COMMUNITY DEVELOPMENT DEPARTMENT  
501 Delta Avenue ♦ Marysville, WA 98270 ♦ (360) 363-8000

**Re: PA23-023 – Spitzenberg Apartments – Technical Review 1**

RE: Spitzenberg Apartments, File# PA23-023  
Construction of 9-unit apartment building. Existing single family residence to be demolished, existing 5-unit apartment building to be retained.  
1902 Grove St. & Parcel # 30052800105700

SITE PLAN

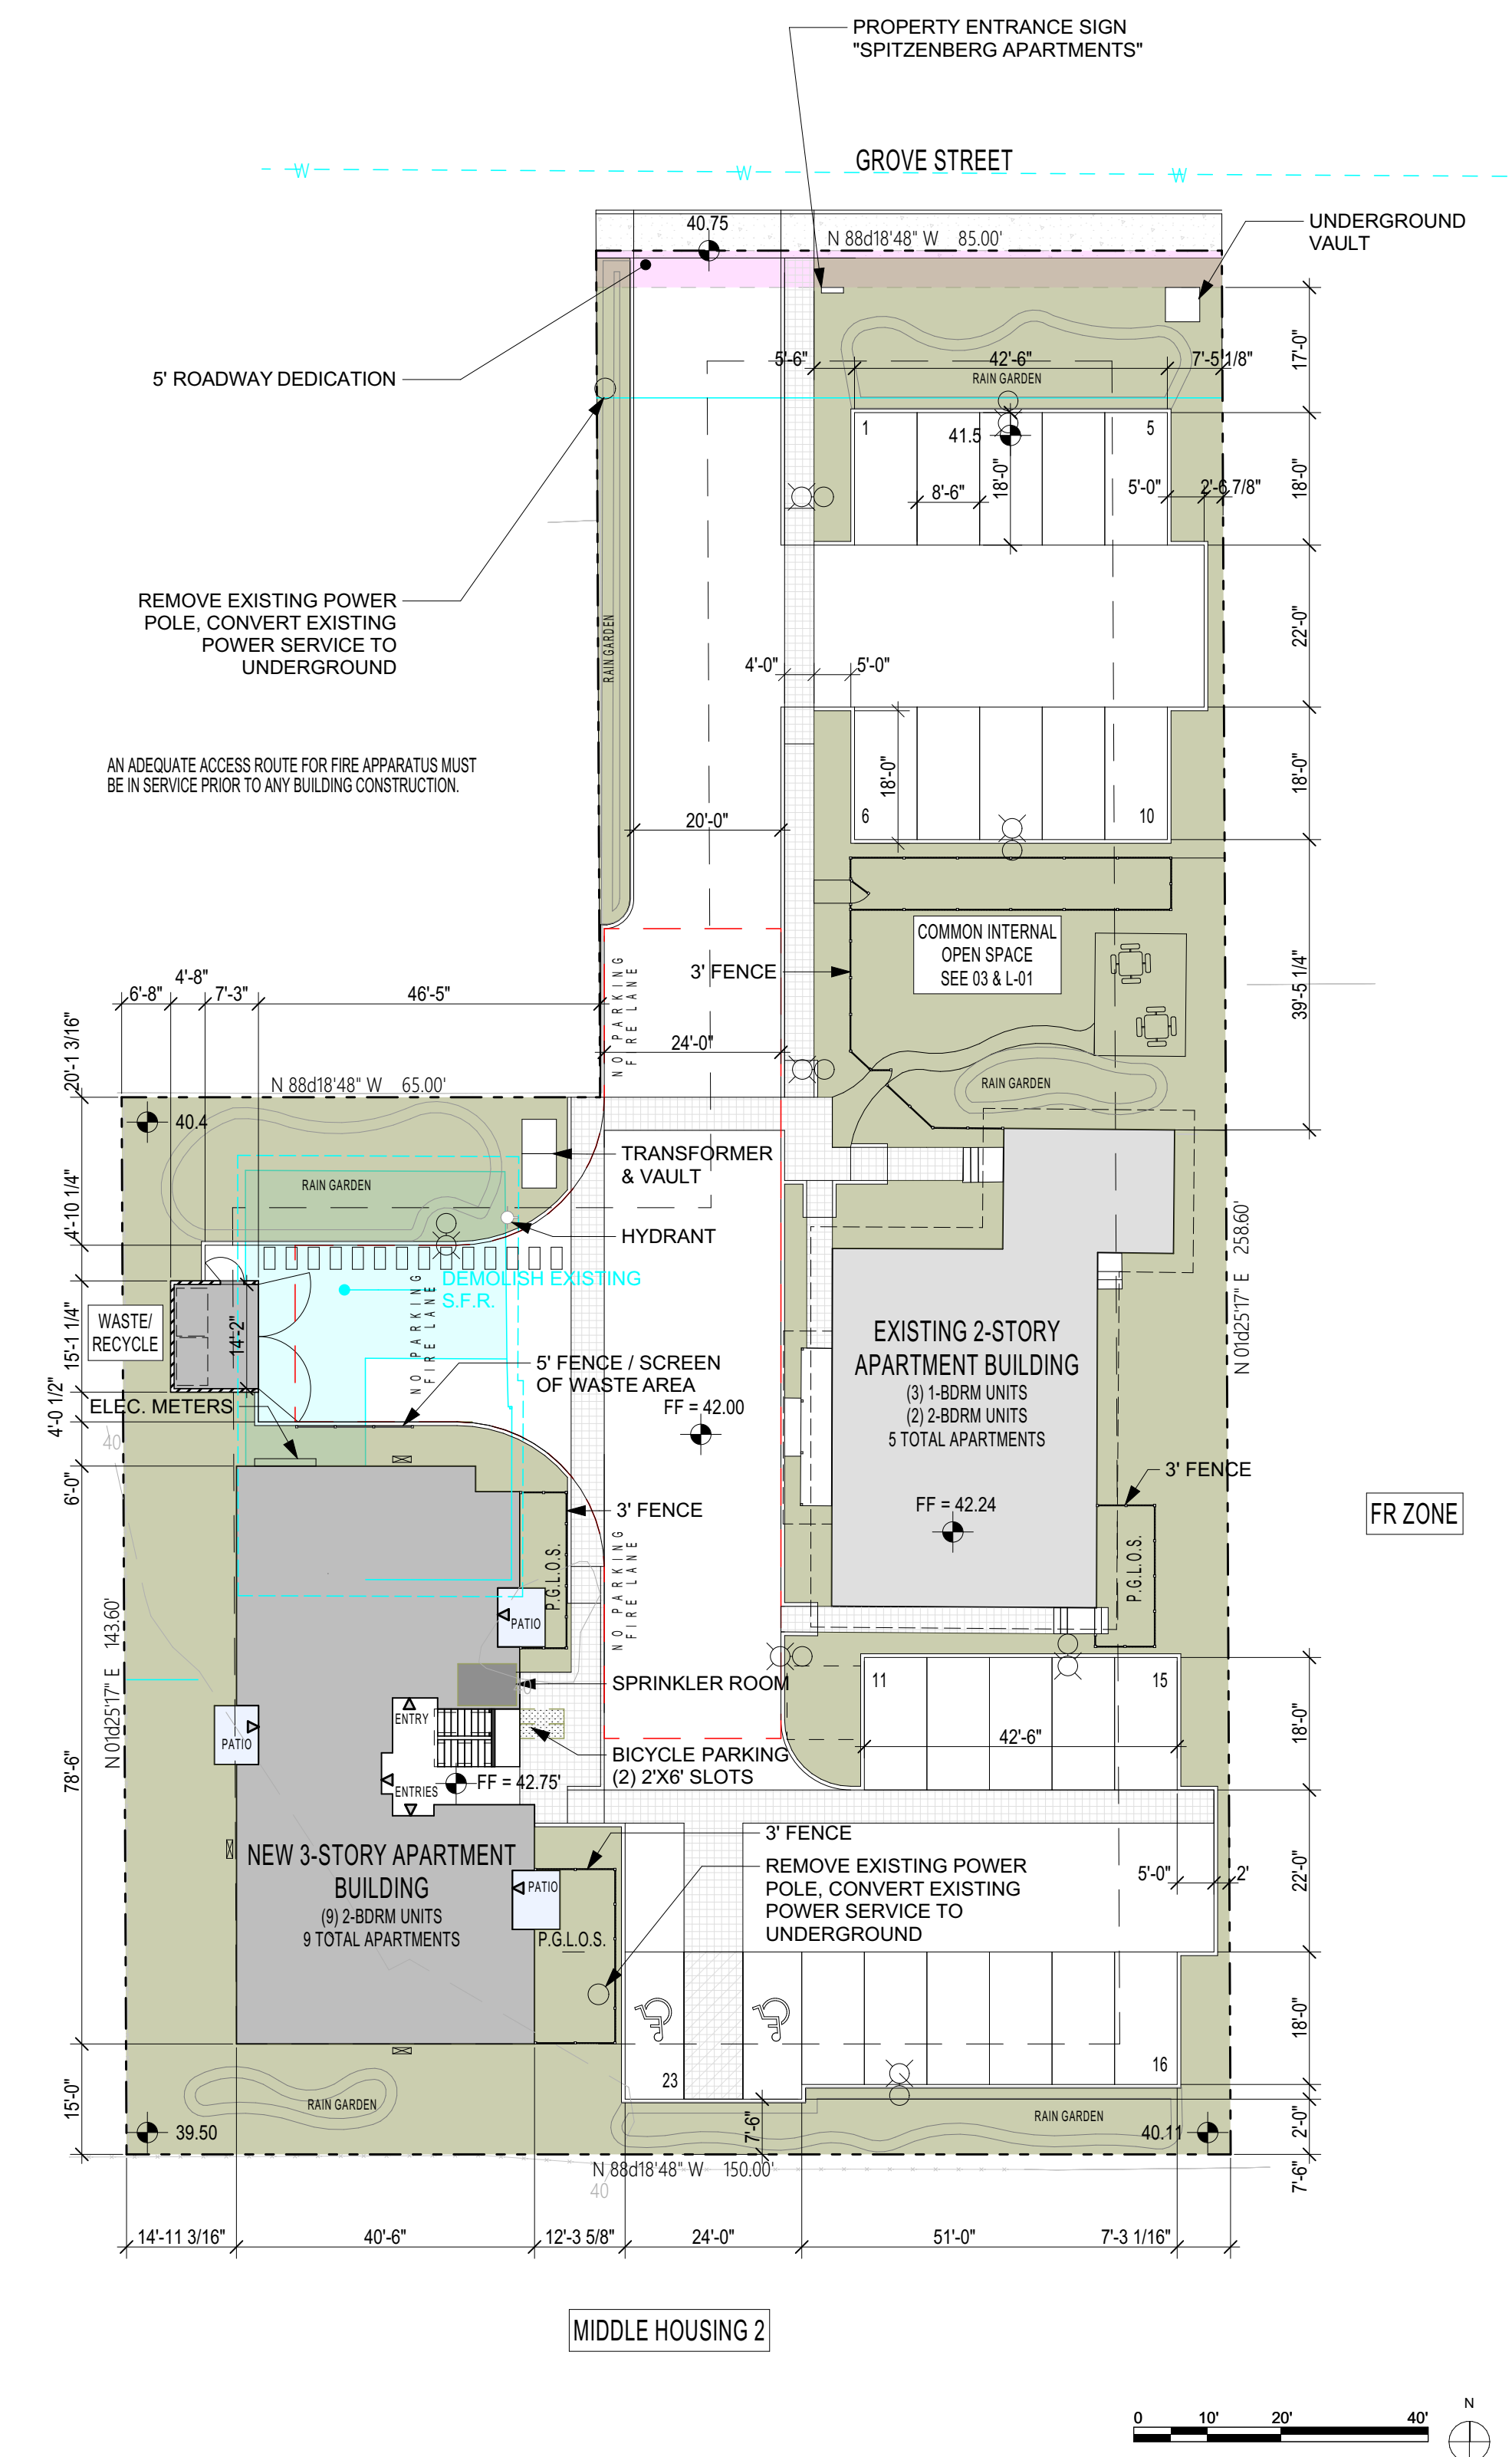
1. A clearly defined walking path shall be provided to the dumpster enclosure. As currently proposed, it appears a resident would have to walk in the rain garden in order to access the pedestrian door for the enclosure.

2. Please provide detail of the proposed dumpster enclosure. The following are design requirements for the enclosure.
  - A structural enclosure shall be constructed of masonry, architectural concrete, heavy-gauge metal, or decay-resistant material that is also used with the architecture of the main building. The director may allow materials other than those used for the main building if the finishes are similar in color and texture or if the proposed enclosure materials are more durable than those for the main structure. The walls shall be sufficient to provide full screening from the affected roadway, pedestrian areas or adjacent use. The enclosure may use overlapping walls to screen dumpsters and other materials.

5. Please identify how the private ground level open space will be enclosed, and how it is accessed from individual units. It appears that the areas proposed adjacent to the new building will be planted with ground cover and 'general landscaping'. This is not likely a surface that lends itself to usable private open space.

7. Much of the space within the required 15-foot L3 buffer along Grove Street does not have any trees and does not meet the planting requirements for an L3 buffer. Shrubs should be spaced no more than 4 feet apart. Please revise accordingly.

7. Access planned appears adequate for fire apparatus. Access of 20'to 24' wide is shown on the plan. A minimum 26 feet wide fire apparatus access is required within 20 feet on both sides of fire hydrants. **24' would be acceptable for this development.**
